Traffic Impact Study

Circle K – US-24 & Meridian El Paso County, Colorado

See comments on pages
1-39 throughout

Add "PCD File No.
CS-21-003"

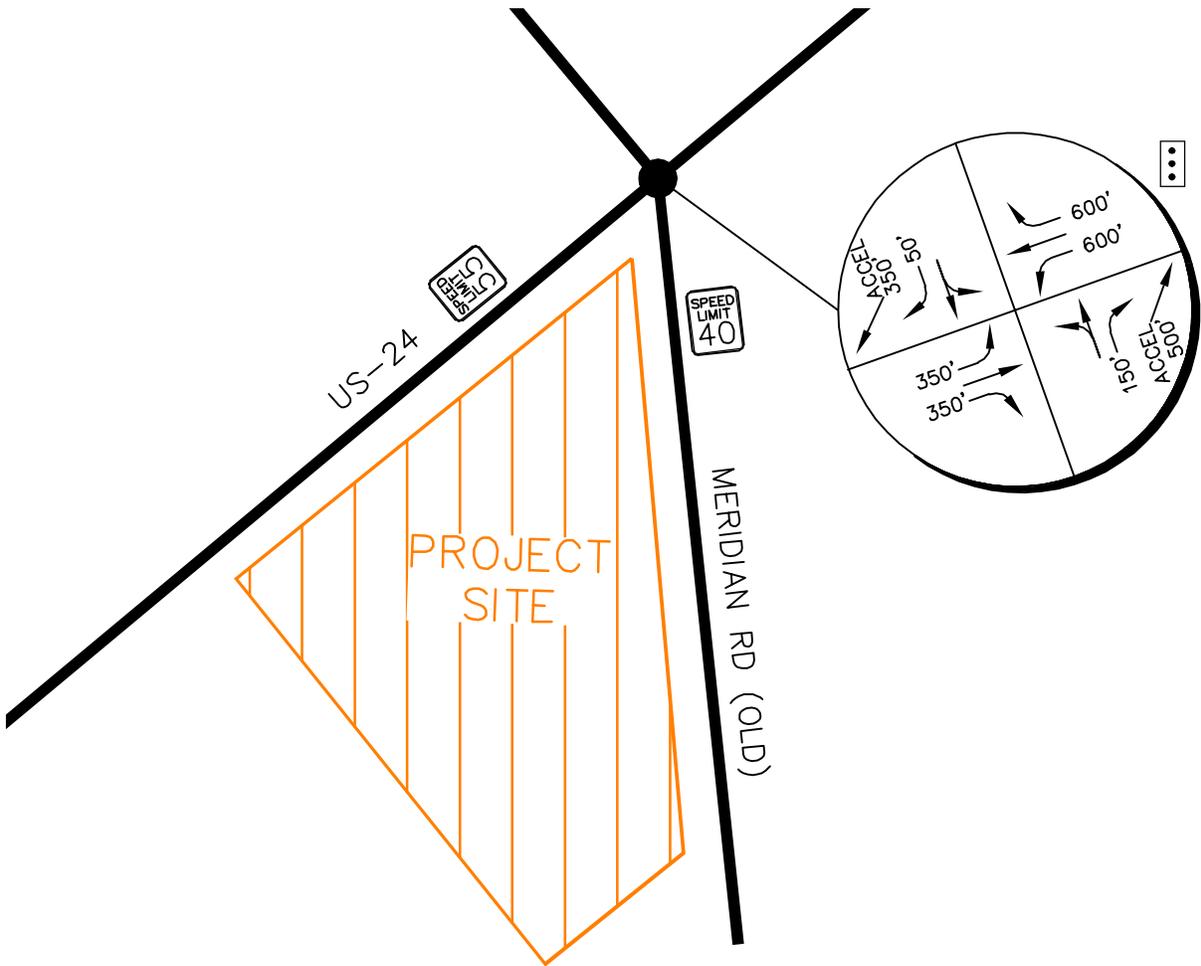
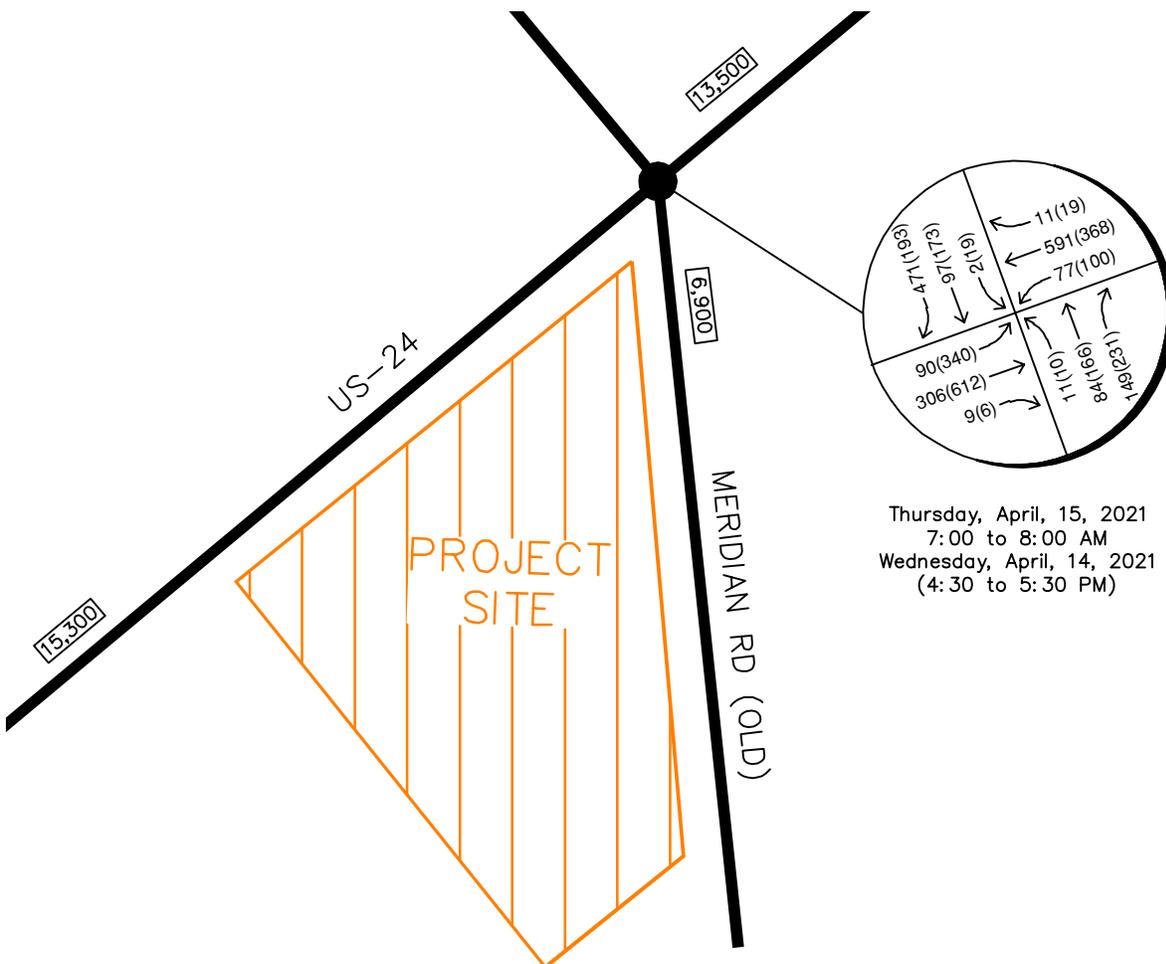
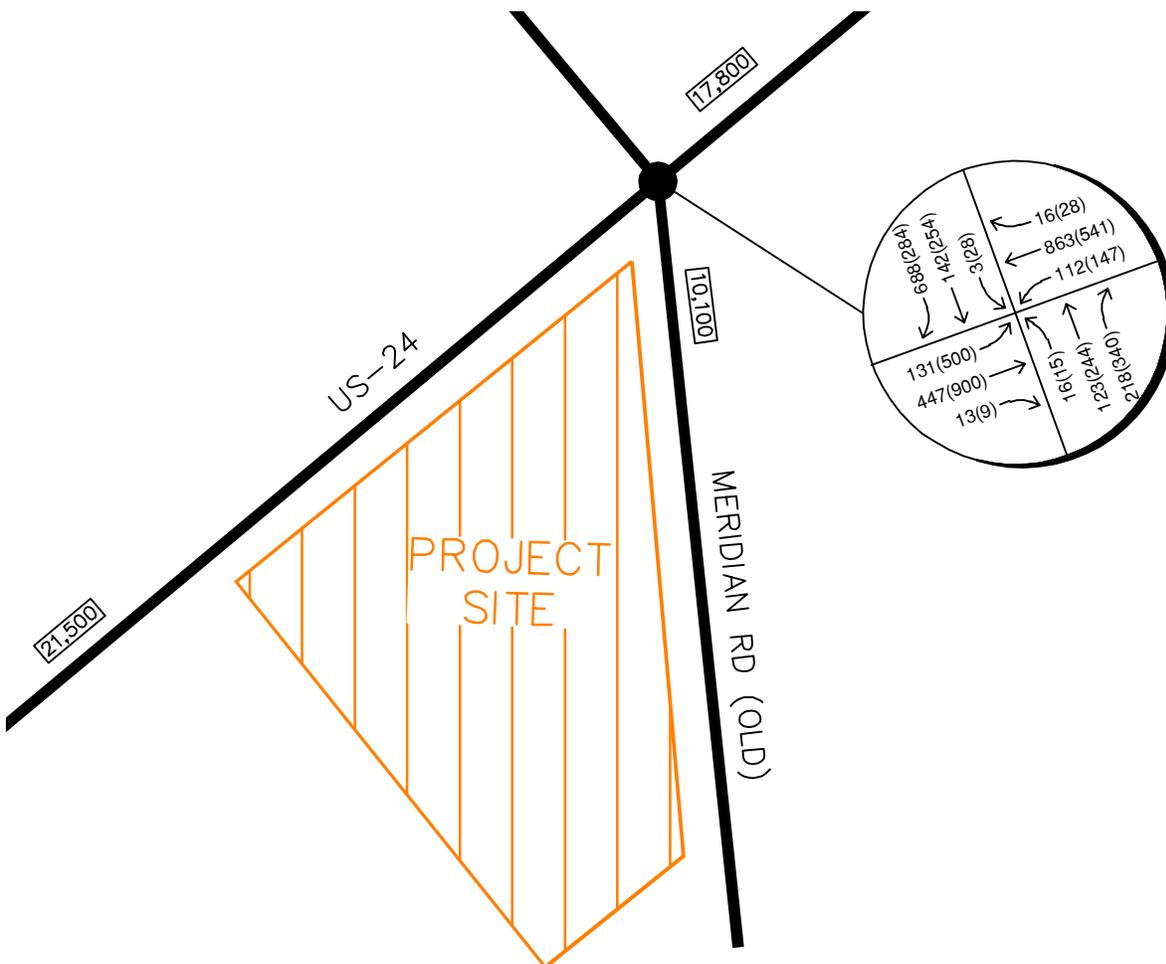
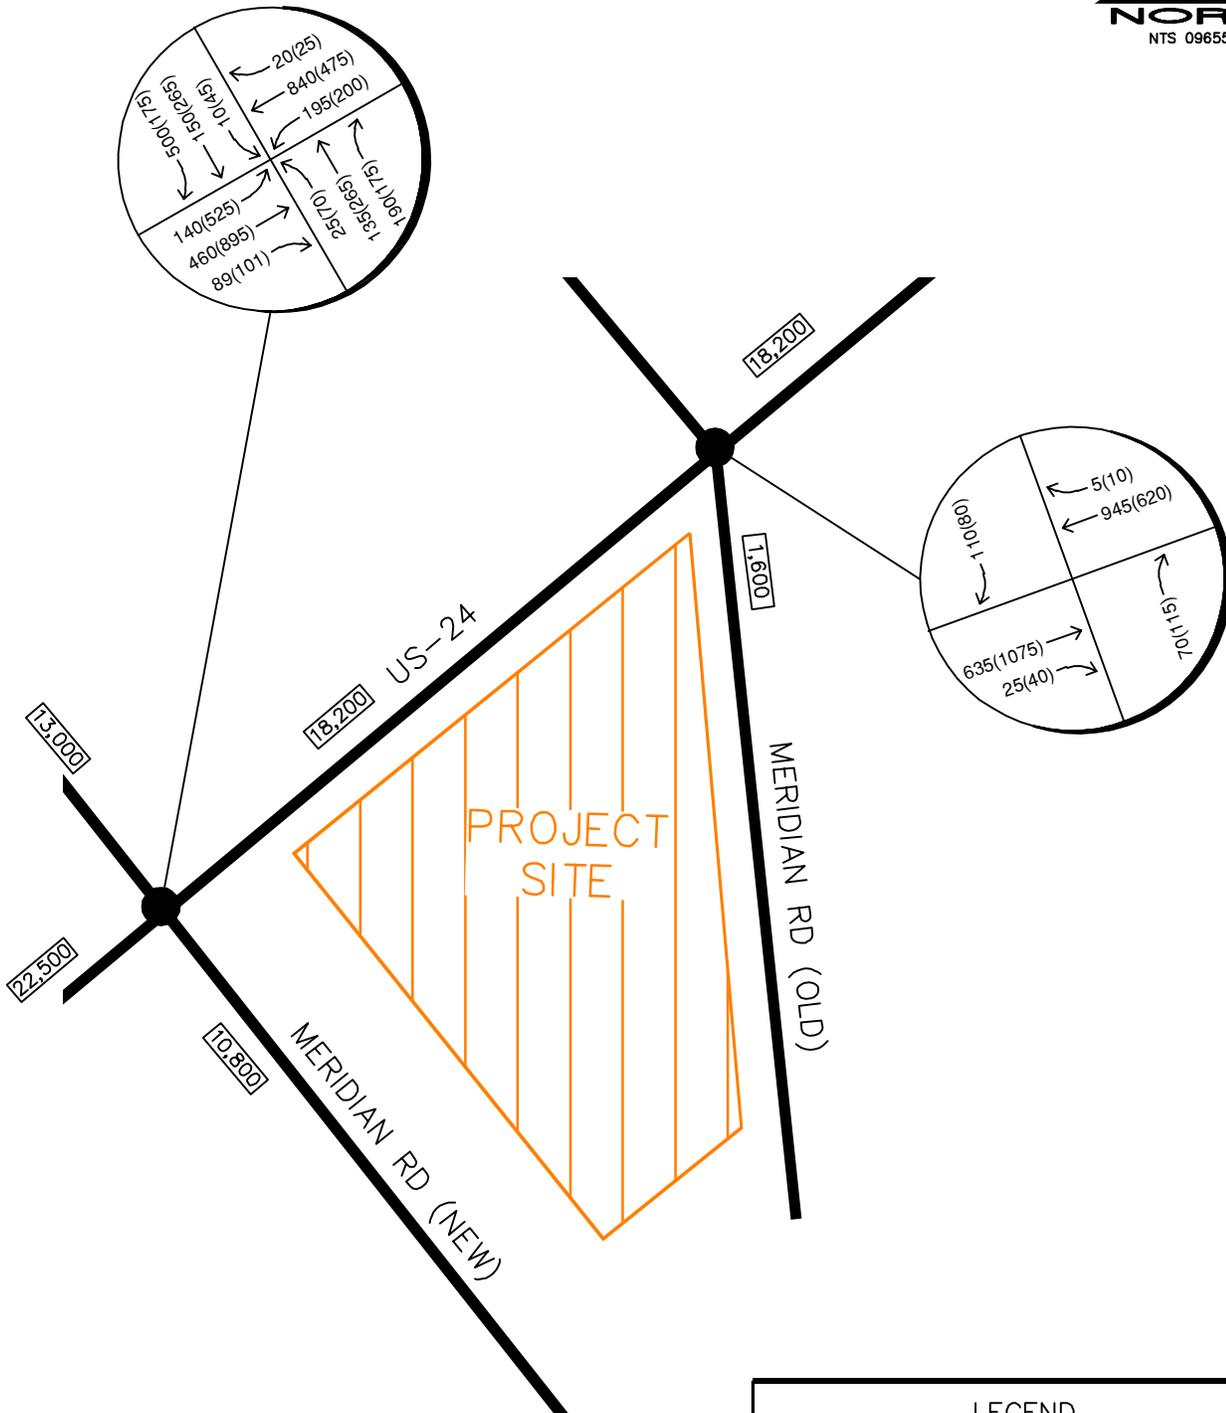
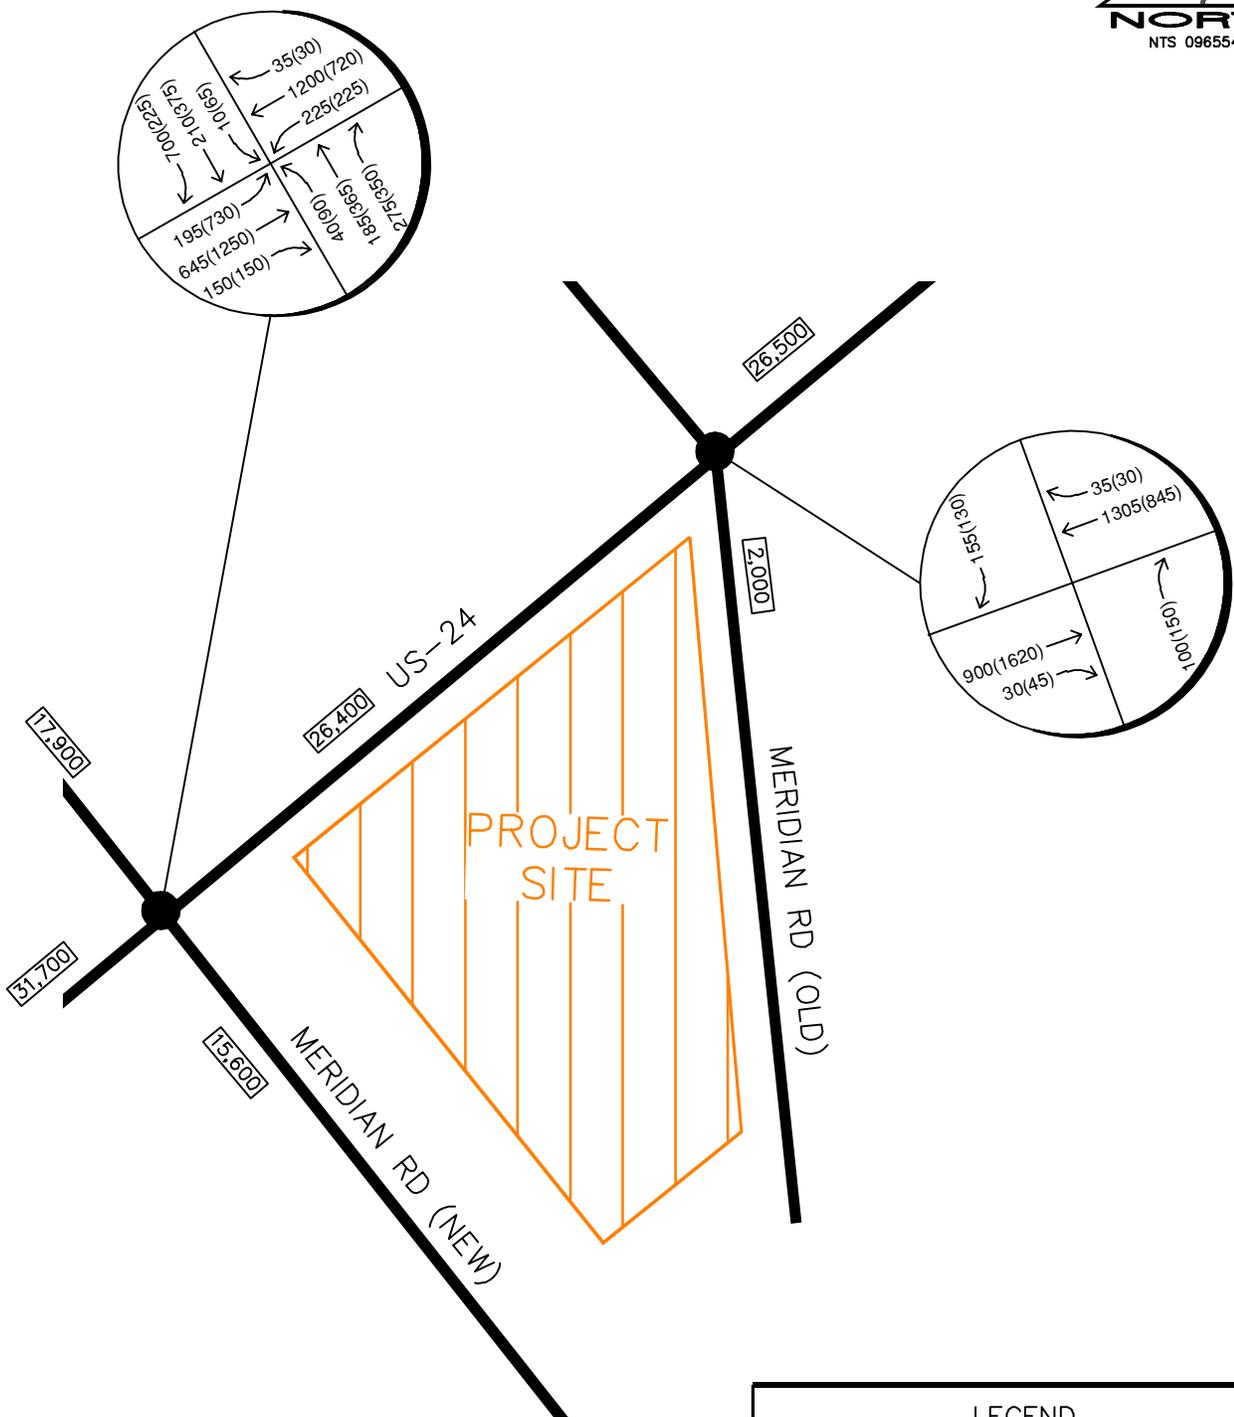
Update hatching to include Lot 2 for all the figure in this TIS. The Traffic Study needs to analyze traffic impact based on the entire requested rezoned properties.

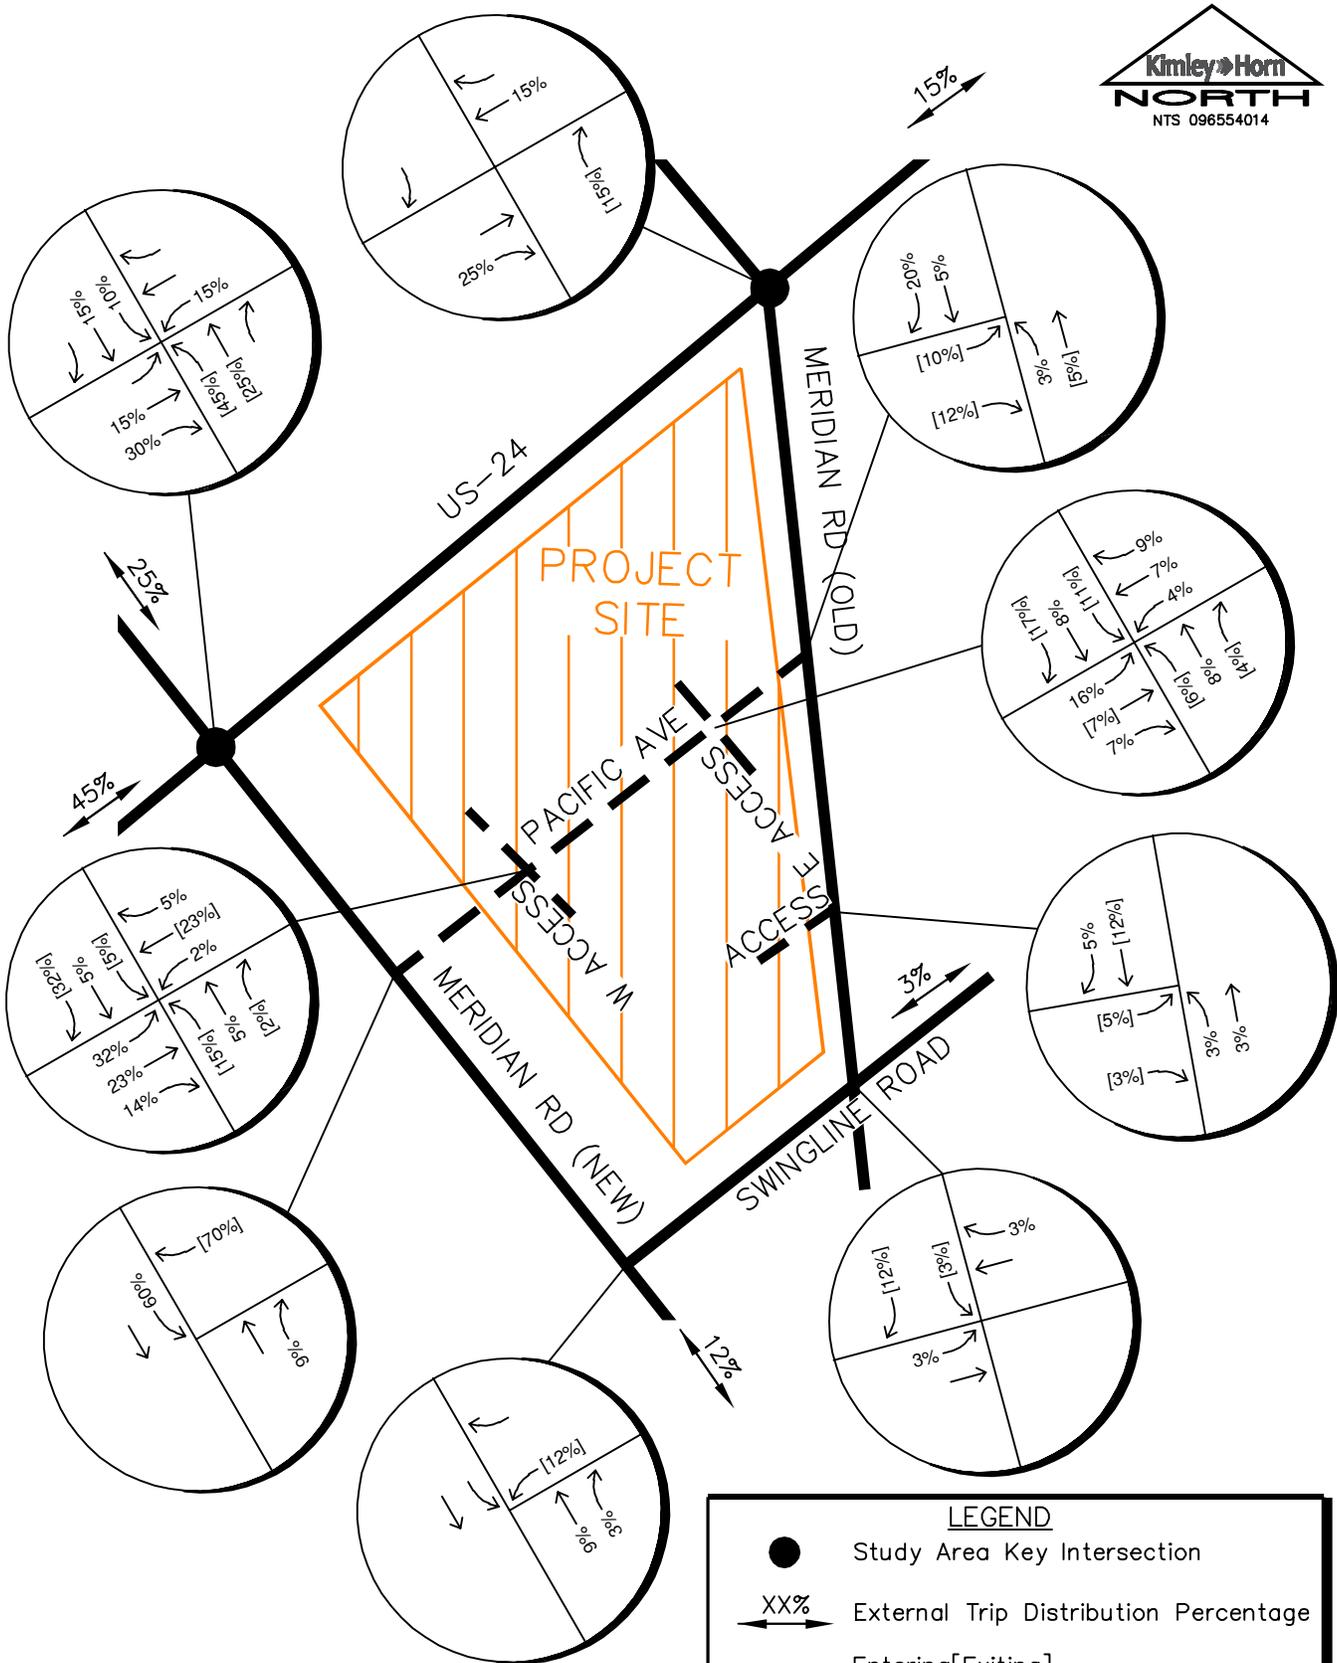
Identify the percent increase used.

Update to include the southern lot 2 w/ highest and best use land use since this is a part of the rezone application
